CITY OF ALBUQUERQUE

Re: Solare Charter School, Phase 1
8801 Gibson Blvd SW
60-Day Temporary Certificate of Occupancy
Transportation Development Final Inspection
Engineer's/Architect's Stamp dated 6-17-19 (M09D031)
Certification dated 2-18-20

Based upon the information provided in your submittal received 2-18-20, Transportation Development has no objection to a 60-day Temporary Certificate of Occupancy based. This letter serves as a "green tag" from Transportation Development for a 60-day Temporary Certificate of Occupancy to be issued by the Building and Safety Division.

TCL

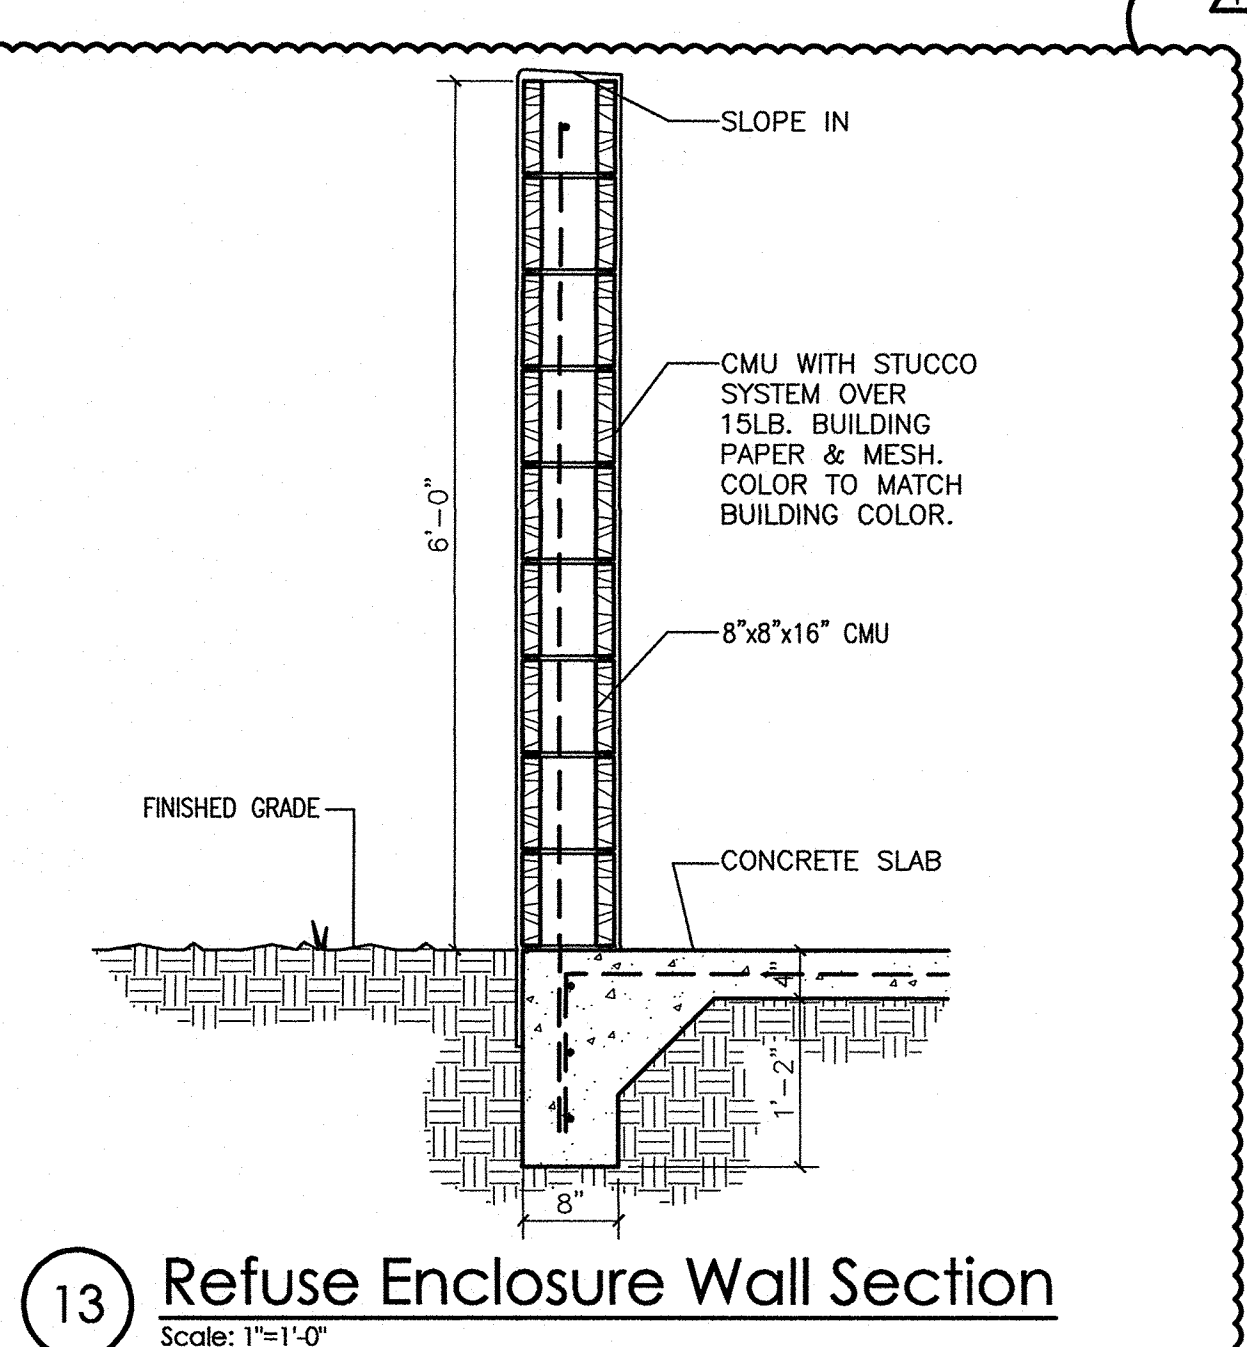
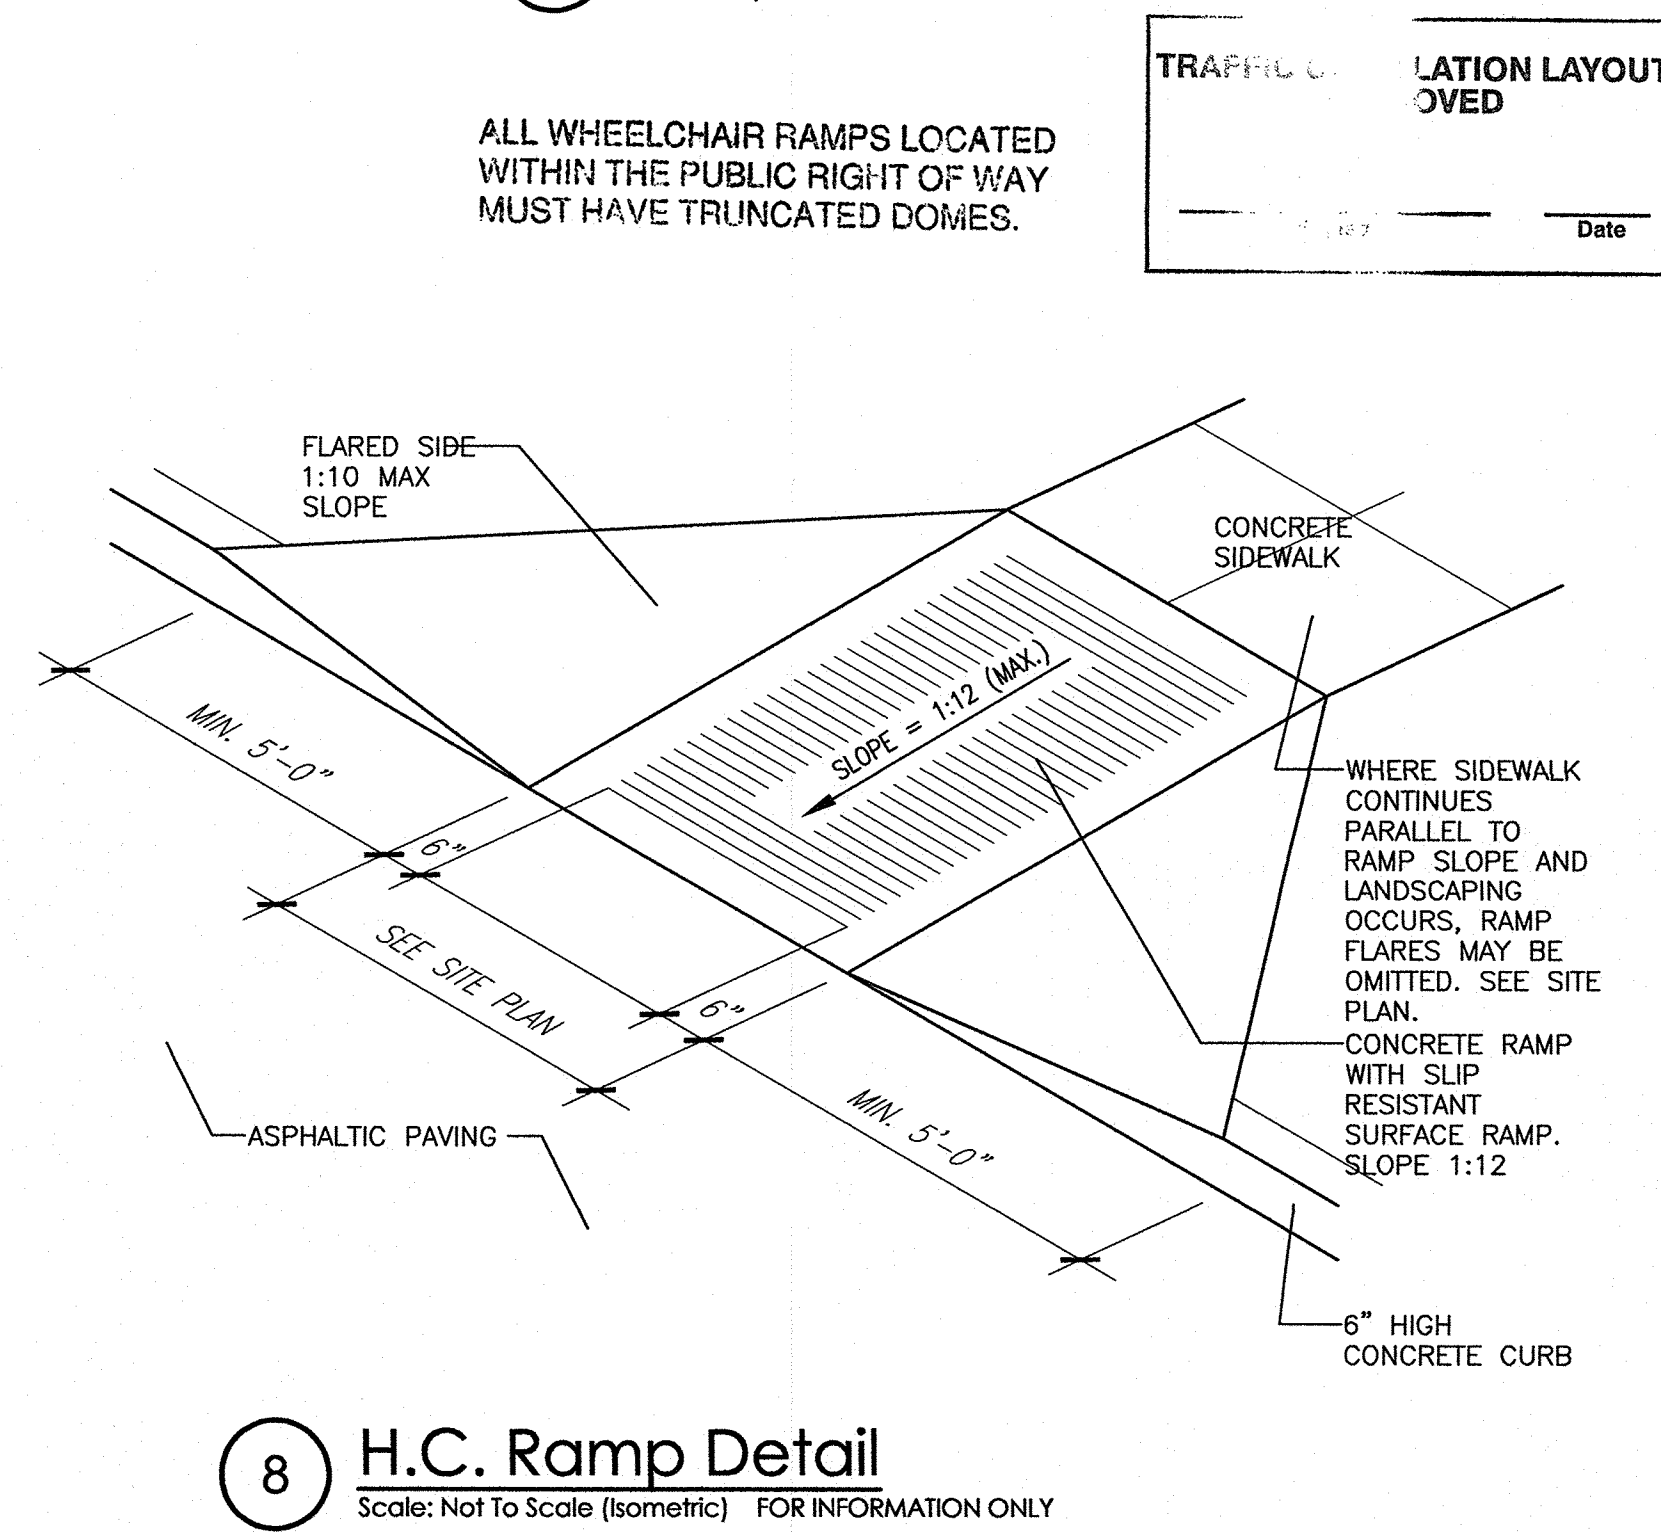
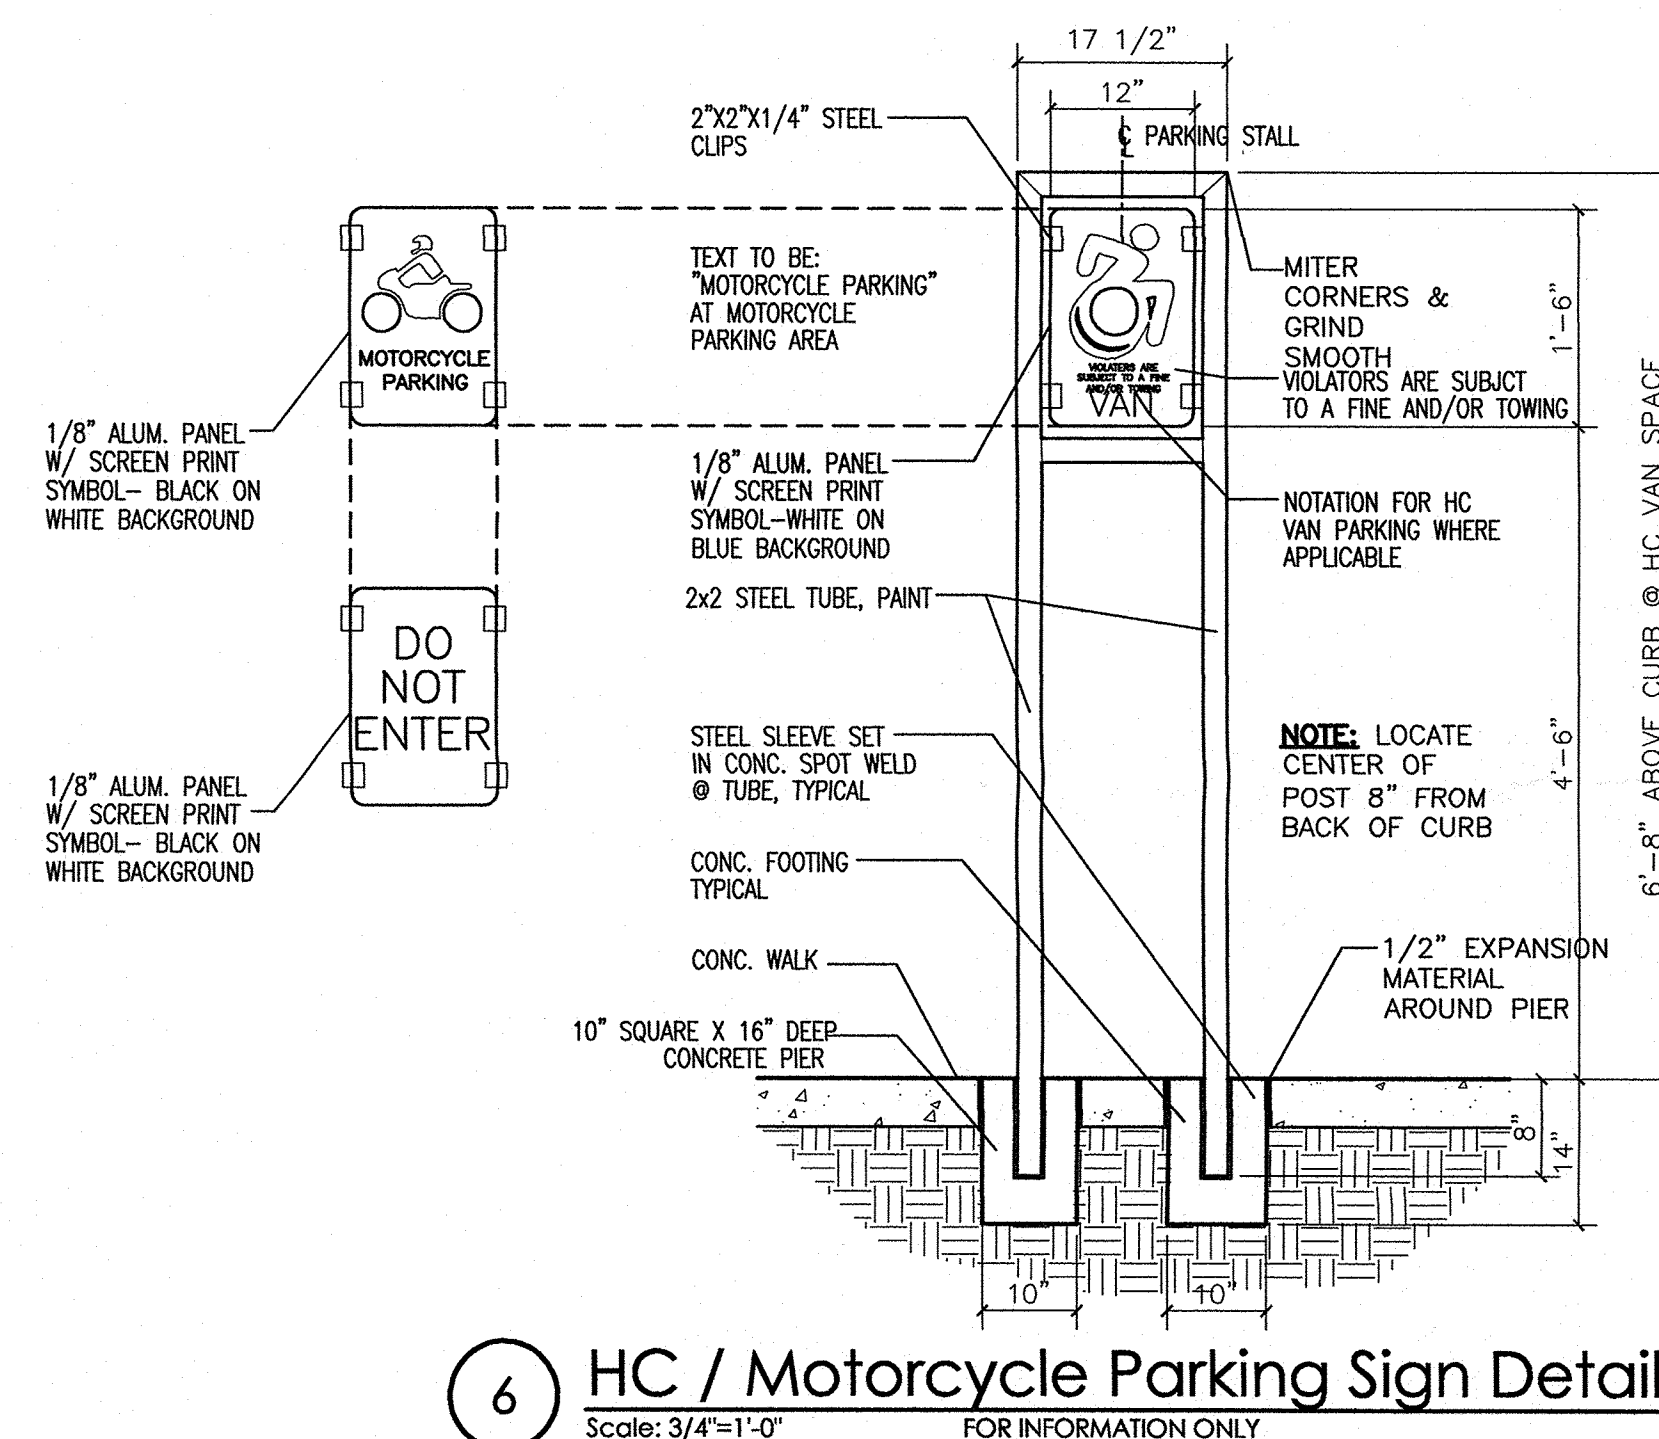
- Please complete bike trail keynote #27.
